## REVISION/DEFERRED SUBMITTAL FORM

Site Address 7216 93rd Avenue SE

Permit Number 2104-090

Revised tank location and elevation, revised pump system for stormwater.

T.E.S.C. PLAN
LOT 1 - SFR (93RD AVE SE)

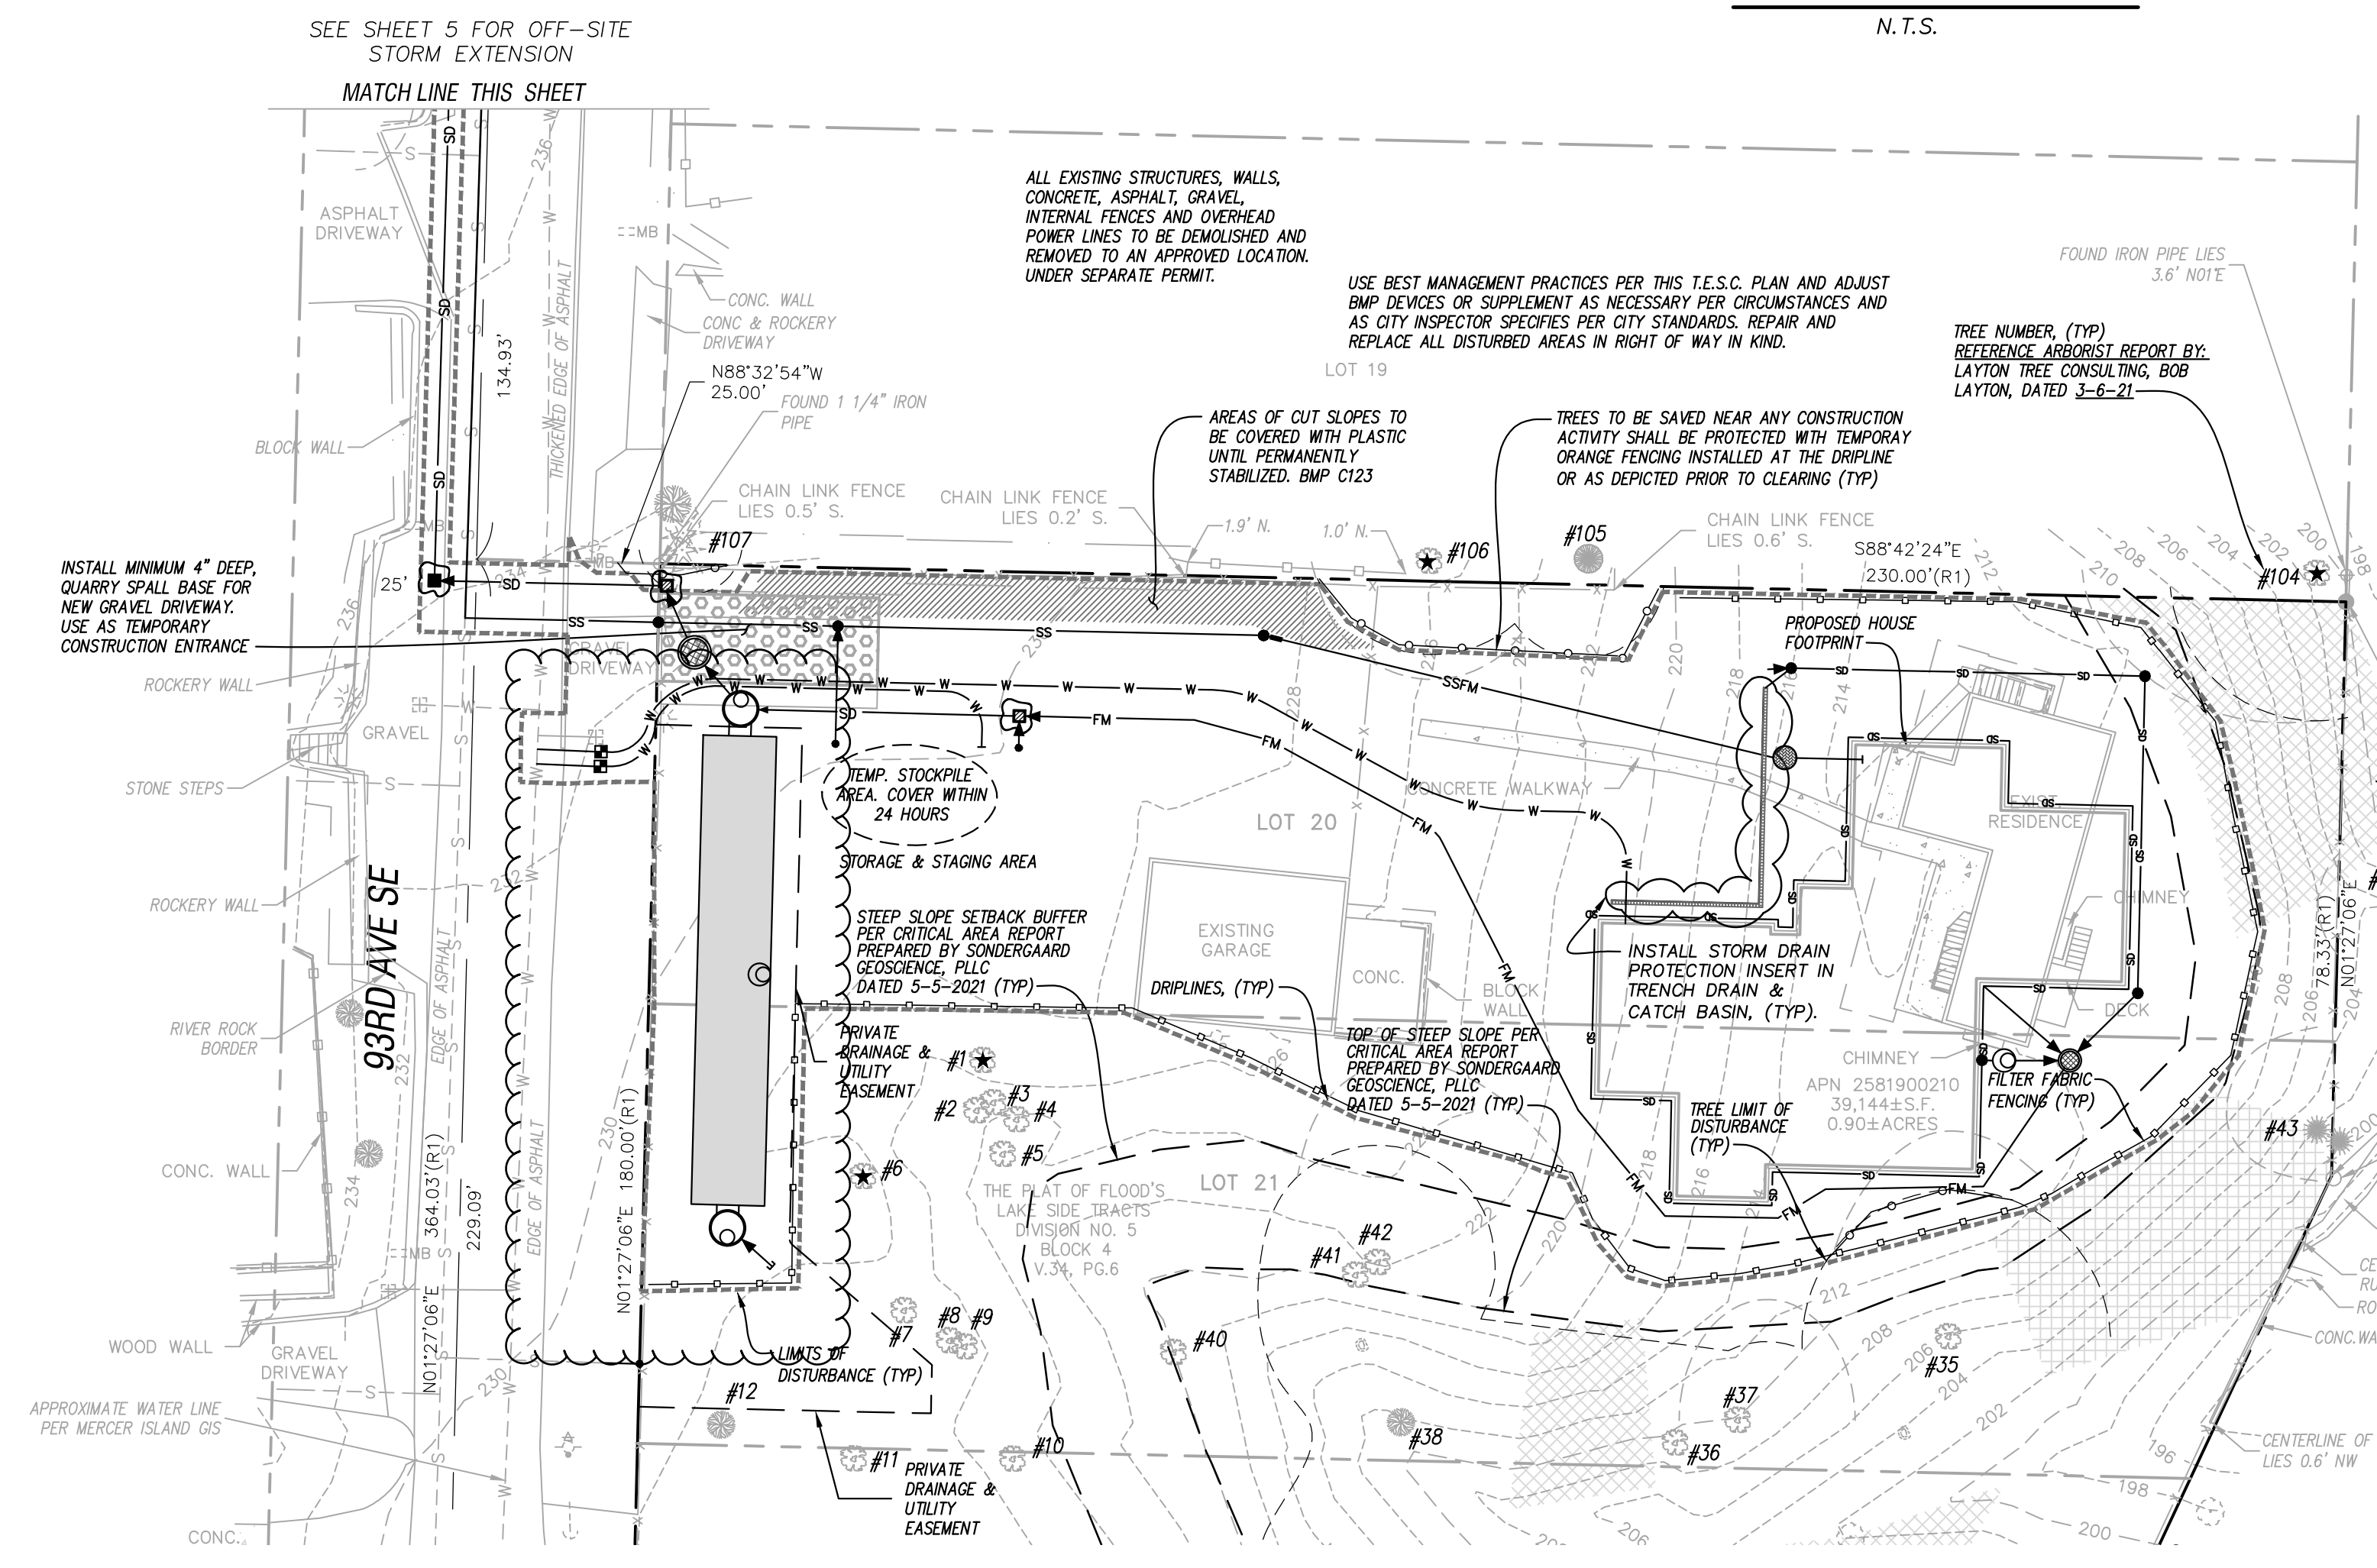
Sheet #	2	Changed clearing limits for revised tank locations.
Sheet #	3	Revised tank location and storm pump system
Sheet #	4	Updated details for new design
Sheet #		
Sheet #		
Sheet #		
Sheet #		
Sheet #		
Sheet #		
Sheet #		
Sheet #		
Sheet #		
Sheet #		
Sheet #
